ALBUQUERQUE FIRE DEPARTMENT
FIRE PREVENTION BUREAU

DISAPPROVED FOR DRAINAGE

1100 LOMASH HW

Developed Drainage Calculations

PROJECT: DR. R.C. TORRES OFFICE BLDG. & TOWNHOUSES
#80-02

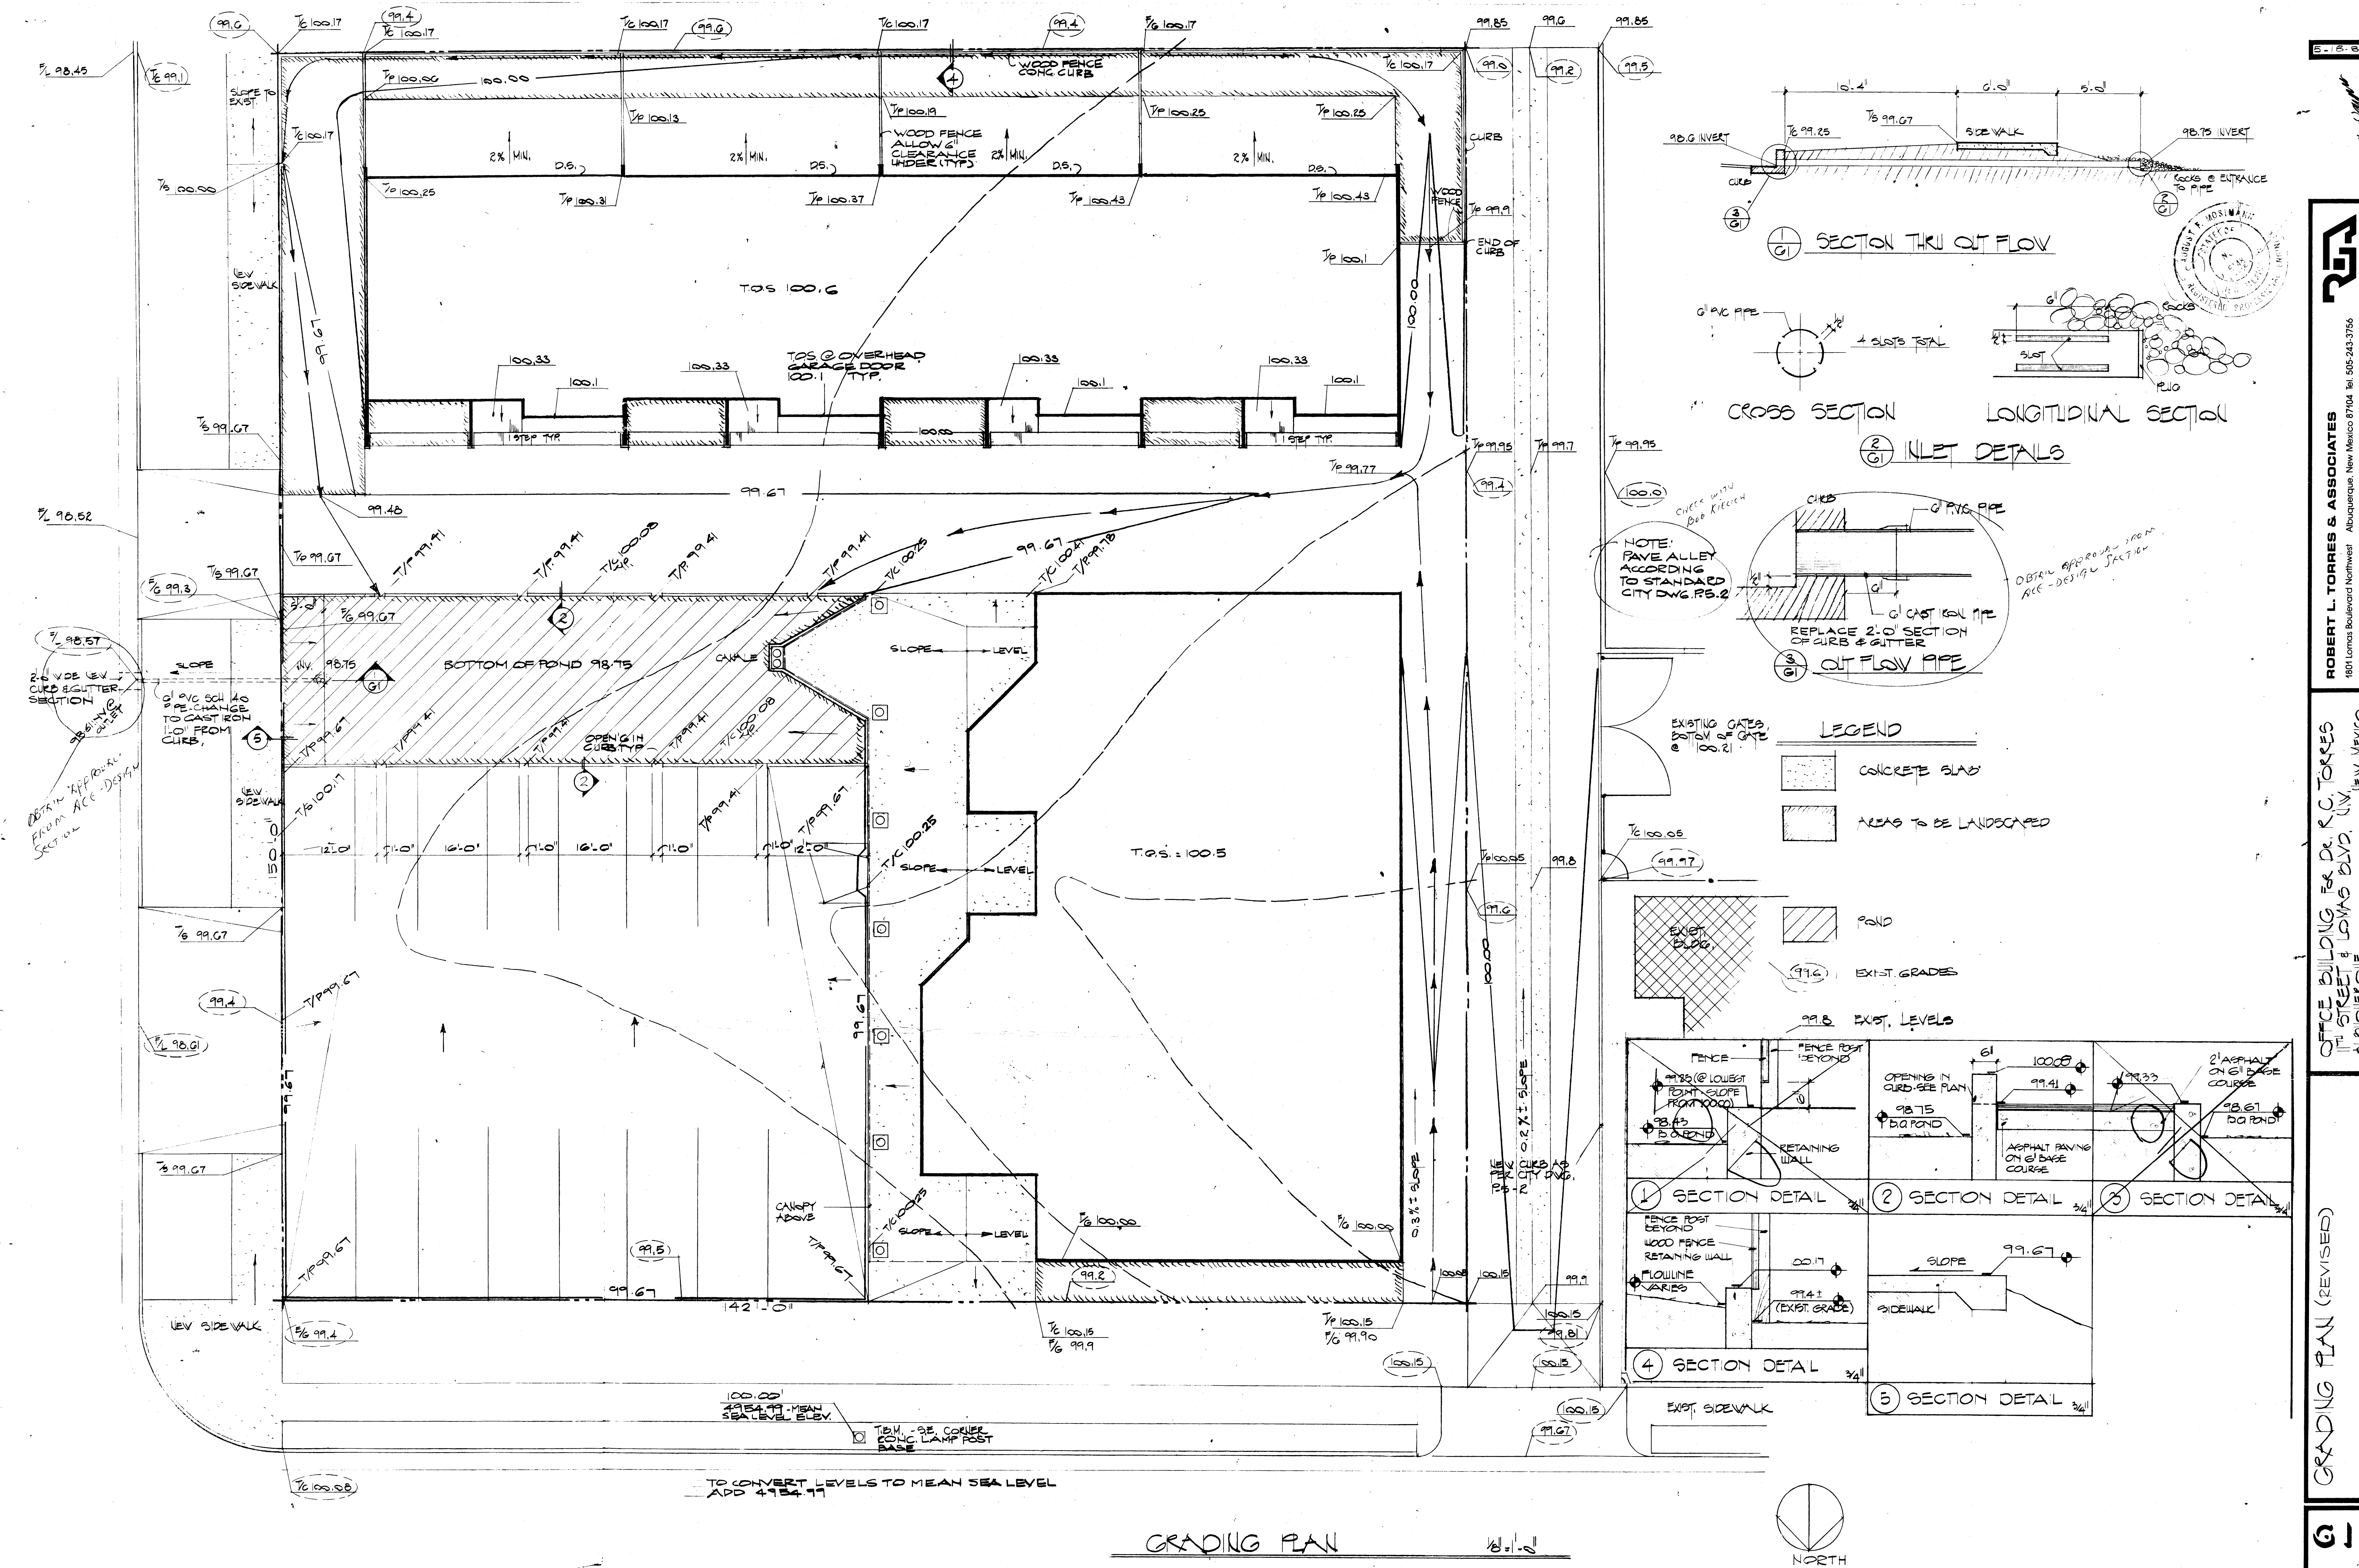
SUBMIT MY ORIGINAL COMMENTS
AND ALL THE SUPPORTING DATA,
SUCH AS:

1. CALCULATIONS SHOWING REQUIRED
POND VOLUMES
2. POSITIVE DISCHARGE OF POND
WITH REQUIRED RATE CALCULATIONS
AND DAFIC CALCULATIONS
3. ALLEY GRADES APPROVED BY
THE A.C.E. DESIGN
4. RECOMMEND A MEETING
TO REVIEW YOUR PROPOSED
DRAINAGE PLAN
